City of Albuquerque Stormwater Construction Site Inspection Report

ESC File No.	Q16E5000A	Project Name:	Kairos Power
NPDES Id. No.	NMR1004XE	Location:	5201 Hawking Dr SE
8/2/2023	Owner	Contractor	
Operator	Kairos Power	Kairos Power	
Contact name & title	Lara Gutierrez	Lara Gutierrez	
e-mail	gutierrez@kairospower.com	gutierrez@kairospower.com	
Contact Phone #	510-808-5265	510-808-5265	
COA Inspector	Chancellor English	Start/End Time:	12pm
Construction Phase:	foundations, vertical structure		
Type of Inspection:	Regular	Storm Event	Post Storm Event >0.25"
Weather at time of inspection?	Clear	Temperature:	~ 95
Estimated date of last storm 0.25" or greater	5/22/2023

EROSION AND SEDIMENT CONTROL PLAN

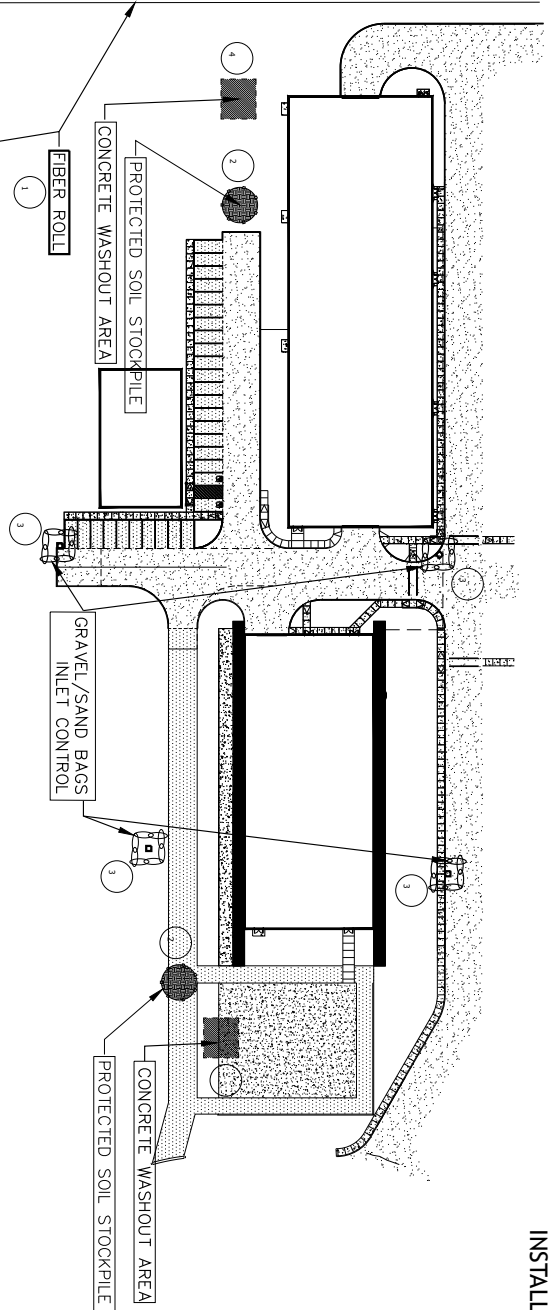
Item Number	Deficiency/ Corrective Action
1	Posting of permit coverage was missing. Required mitigation: You must post a sign or other notice of your permit coverage at a safe, publicly accessible location in close proximity to the construction site per CGP Part 1.5.
2	The SWPPP and self-inspection reports are not current and up-to-date. The SWPPP has not been certified. The Landscape Plan in the SWPPP is not current as it is for Phase 1 and not the phase currently ongoing. The last self-inspection report observed was 9/1/22. Required mitigation: Your signatory must sign and date your SWPPP in accordance with CGP Appendix G, Part G.11 as per CGP Part 7.2.10. You must include stabilization measure in the SWPPP per CGP Part 7.2.6.vii. You must, at a minimum, conduct a site inspection once every 14 calendar days and within 24 hours of a storm event that produces 0.25 inches of rain within a 24-hour period as per CGP Part 4.2 and City Ordinance 14-5-2-11.

3	Silt fence and fiber rolls are missing from what is shown on the SWPPP map. Required mitigation: Re-install BMPs to reflect what is shown on the SWPPP map or modify the existing SWPPP map to reflect current conditions on the ground. Either ensure all stormwater controls are maintained and remain in effective operating condition during permit coverage per CGP Part 2.1.4 or you must modify your SWPPP, including the site map, within 7 days if you make changes to your construction plans, stormwater controls, or other activities at your site that are no longer accurately reflected in your SWPPP per CGP Part 7.4.1.
4	Washout was observed on bare soil and not in the available washout stations. Required mitigation: Remove and discard construction wastes as required per CGP Part 2.3.3. Direct wash water into a leak-proof container or a leak-proof and lined pit. Do not allow liquid wastes to be disposed of through infiltration or to otherwise be disposed of on the ground as per CGP Part 2.3.4.
